2023/0838

10 Higham Common Road, Barugh Green, Barnsley, S75 1LD

Single storey front extension to dwellinghouse and widening of vehicular access and front of dwelling parking area (Amended Plans).

PLAN & ELEVATIONS Rev B

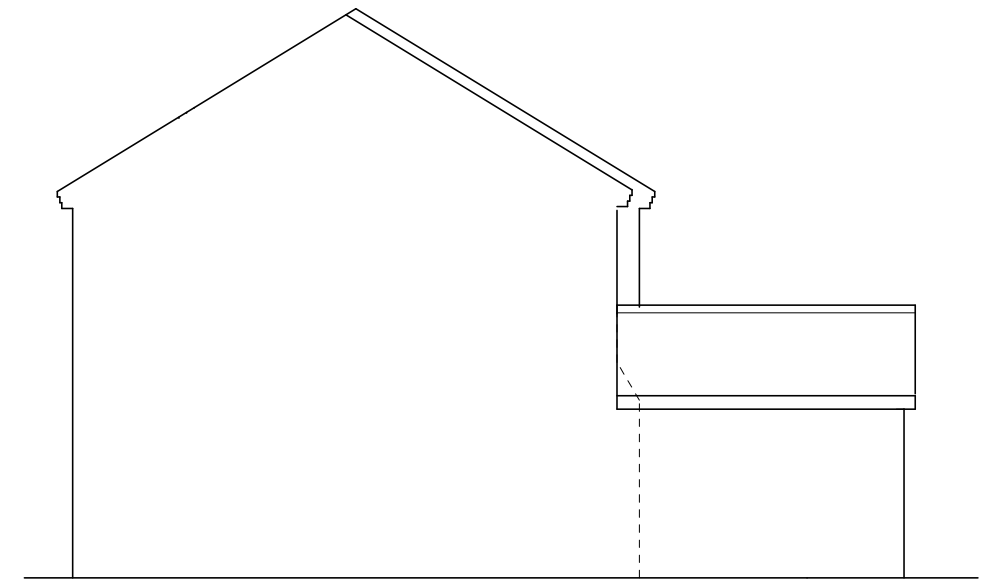
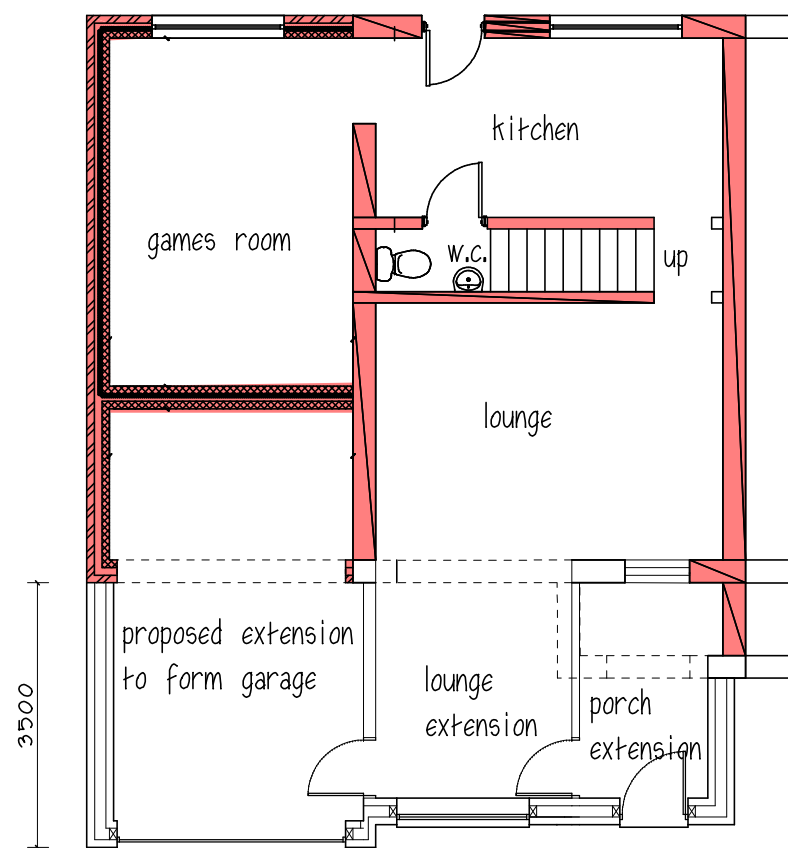
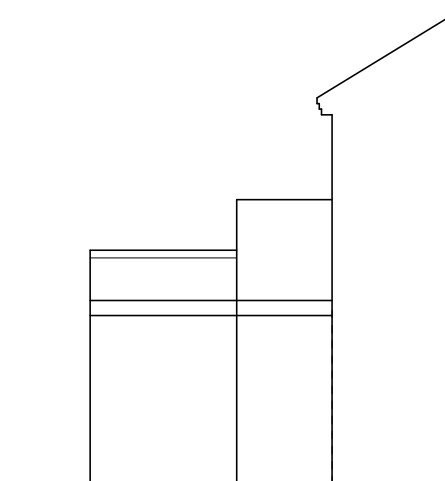
In this instance, the proposed extension would be visible from the public realm of Higham Common Road and initial concerns were raised regarding its scale, the lack of symmetry maintained with the adjoining semi-detached property, and the loss of soft landscaping, including areas of grass and the boundary wall to the front. The culmination of these concerns could have been particularly averse to the character of the street scene, especially as residential properties in the immediate locality are generally differentiated and fronted by a form of soft landscaping enclosed by a boundary treatment.

There are several examples of similar types of development within the street scene and immediate locality; however, such extensions are often much smaller in scale compared with that which is proposed. Therefore, it is acknowledged that there could be some impact to the character of the street scene. The existing street scene is varied comprising two-storey terraced and semi-detached properties of varying scale and appearance. Existing larger, flat roof extensions to the rear of properties located near the junction of Higham Common Road with Barough Green Road are visible from public viewpoints and are likely to contribute to existing levels of impact. Similarly, existing flat roof porches within the locality and the flat roof building accommodating Barough Green Club are also likely to contribute to existing levels of impact. As such, the potential impact of the proposed extension is not expected nor considered to be unduly harmful, especially as the extension would be setback from the highway and adopt a sympathetic design, including roof type and external materials.

Overall, it is acknowledged that the scale of the extension is relatively large and not entirely in-keeping with the existing character of the street scene; however, the extension would remain subordinate to the existing extended property and would adopt sympathetic features and external materials, retaining some elements that define residential properties in the area. The extension would maintain some degree of symmetry with the adjoining property and would reflect the appearance of existing extensions within the locality albeit to a larger scale. The extension is aesthetically, likely to contribute more positively to the character of the street scene compared with some existing structures.

The proposed extension to the front of the property would enable the enlargement of the existing integral garage. Best practice suggests that the internal floor area of a garage should be 3 metres by 6.5 metres. In this instance, the enlarged garage would achieve approximately 3.2 metres by 5.6 metres. As such, the garage would not be included in the total parking provision of the site; however, it is acknowledged that the space may be sufficient to accommodate some smaller vehicles.

SITE & LOCATION PLANS 1:500, 1:1250 @ A4 C Barnsley S75 3JR

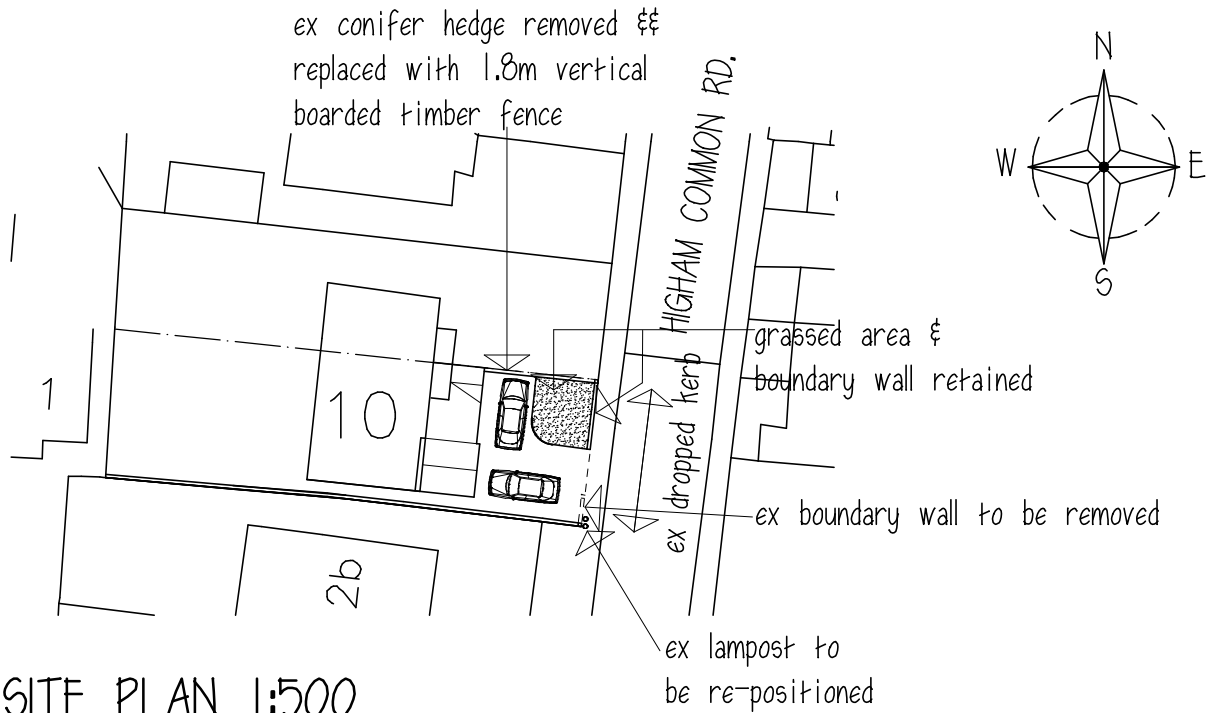
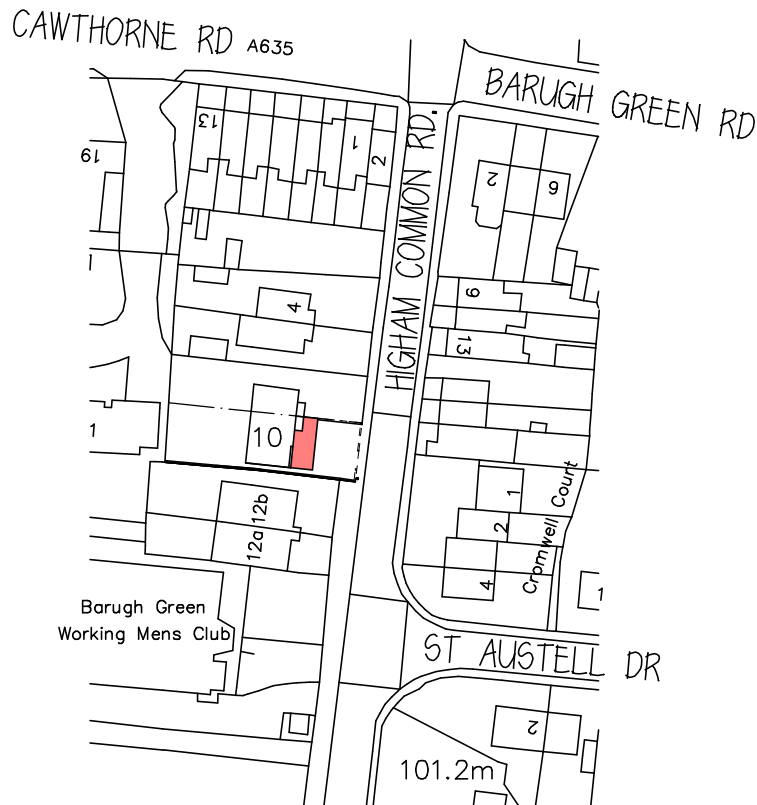
Amended proposals which are subject to consideration were received to address these concerns. The conifer hedge forming the northern boundary treatment would be removed and replaced with timber fencing, and the southernmost part of the front boundary wall would be removed; however, an area of grass to the north-east corner of the application site and the boundary wall immediately adjacent would now be retained. The extension would maintain the projection originally proposed; however, the roof has been altered and would now retain and incorporate the roof of the existing porch to maintain some degree of symmetry with the adjoining property and reduce its presence as a dominating feature. The extension would be constructed of red brick and use grey concrete roof tiles that would match or be of a similar appearance to the external materials of the original dwellinghouse and existing two-storey side extension.
